Re: BusConnects Lucan to City Centre Core Bus Corridor Scheme
Lucan to Dublin City Centre

**OBSERVATION IN RELATION TO
LANDS AT KNOCKMAREE, ST. LAURENCE'S ROAD,
CHAPELIZOD, DUBLIN 20**

**LUCAN TO CITY CENTRE CORE BUS CORRIDOR SCHEME
COMPULSORY PURCHASE ORDER 2022**

PLOT REFERENCE NO. : 1023(1).1f & 1023(2).2f

Drawing File Name: BCIDA-ACM-ENV_LA-0006_XX_00-DR-LL-0020 | Sheet Number: 20 of 31 | Status: A | Rev: M01

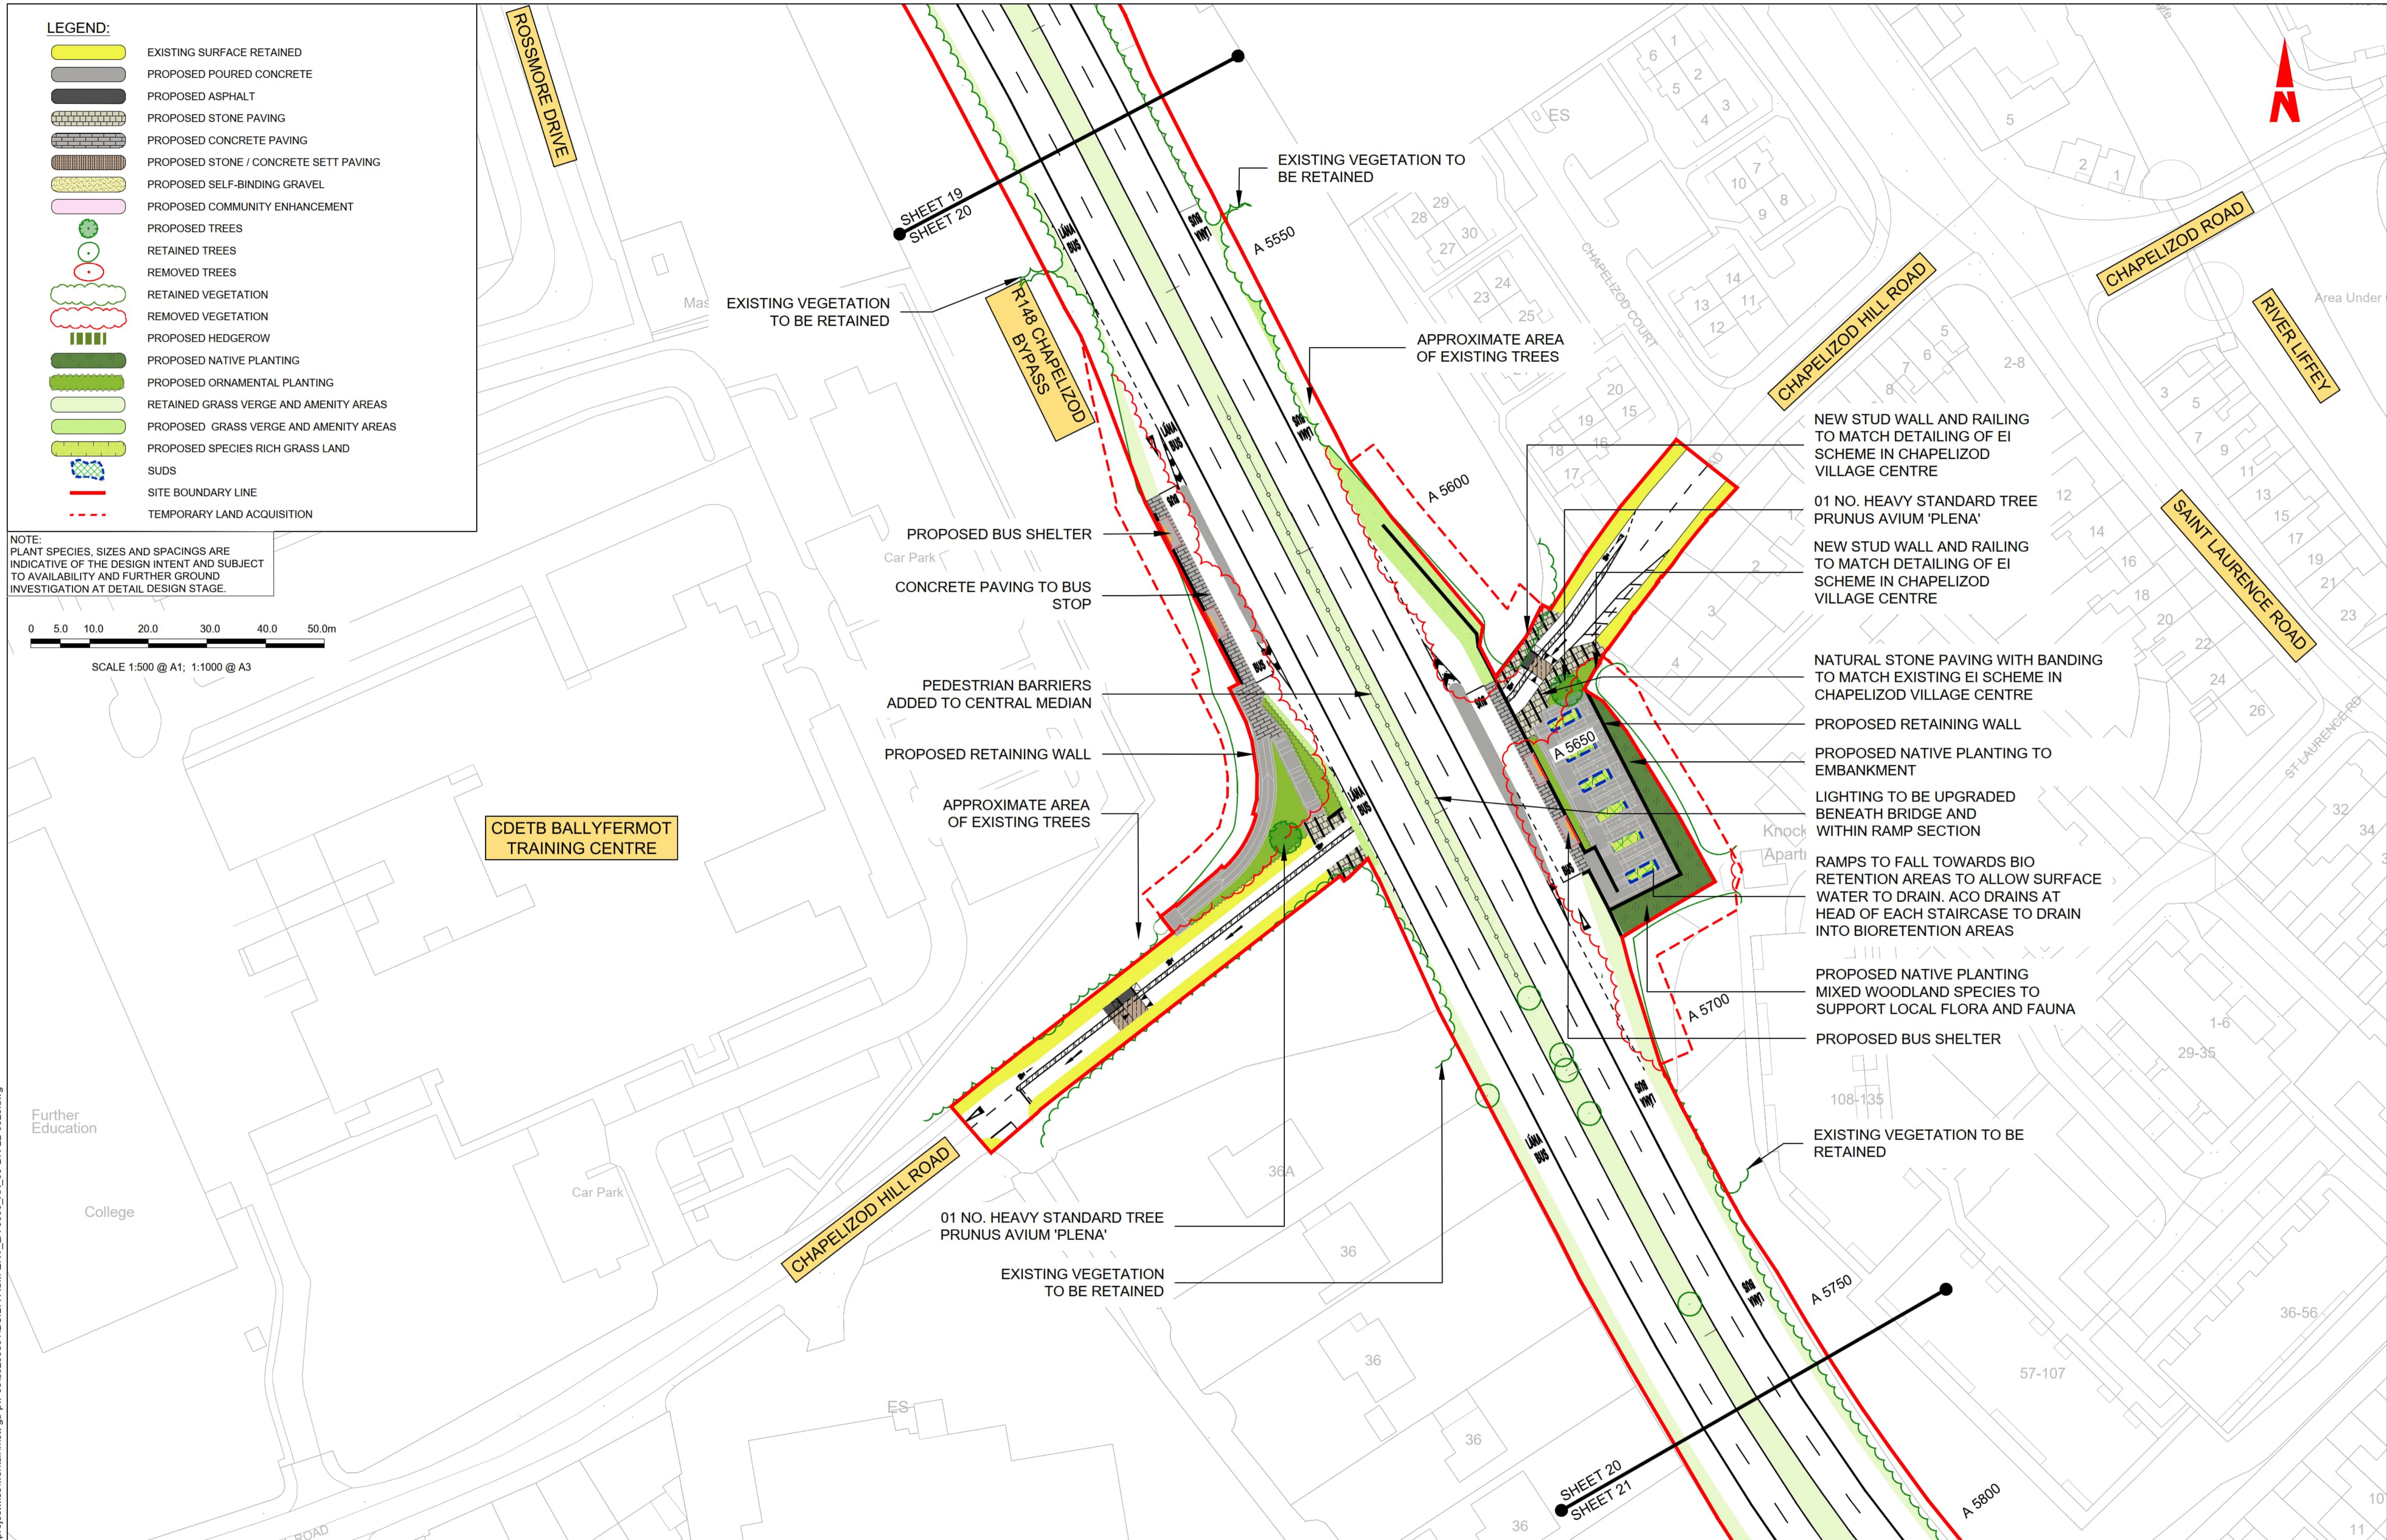
3.6 The drawing (Drawing no. DR-LL-0020 (Sheet 20 of 31) does not adequately indicate the tree cover on the steeply sloping lands, and the extent of the tree cover that will be lost. Assuming that all trees will also be removed within Temporary CPO lands, to facilitate the heavy engineered ground works and supporting structure proposed, we have estimated that all bar the lowest trees will be lost. This is based on a retaining structure being required within a few metres of the substation, and the Temporary CPO extending a corridor around these works to facilitate them. This will have a profound negative impact on the visual amenity and feeling of privacy within Knockmaree.

3.7 There are no details within the Arboricultural Impact Assessment that forms Appendix A17.1 of the EIAR, on the species, quality, condition, spread or maturity of these trees, and therefore their categorisation has not been adequately considered within the EIAR. We respectfully submit that the conclusions of the Arboricultural Impact Assessment within the EIAR are therefore deeply flawed. The hard nature of the works and removal of green infrastructure will also have a significant negative impact on the biodiversity of the area. It is also our understanding that a number of services and utilities run beneath the ground adjacent to the boundary with the existing bypass that will be impacted, and will need to be relocated by the proposed development. Any loss of any service or utilities during the construction works will be unacceptable to the residents of Knockmaree.
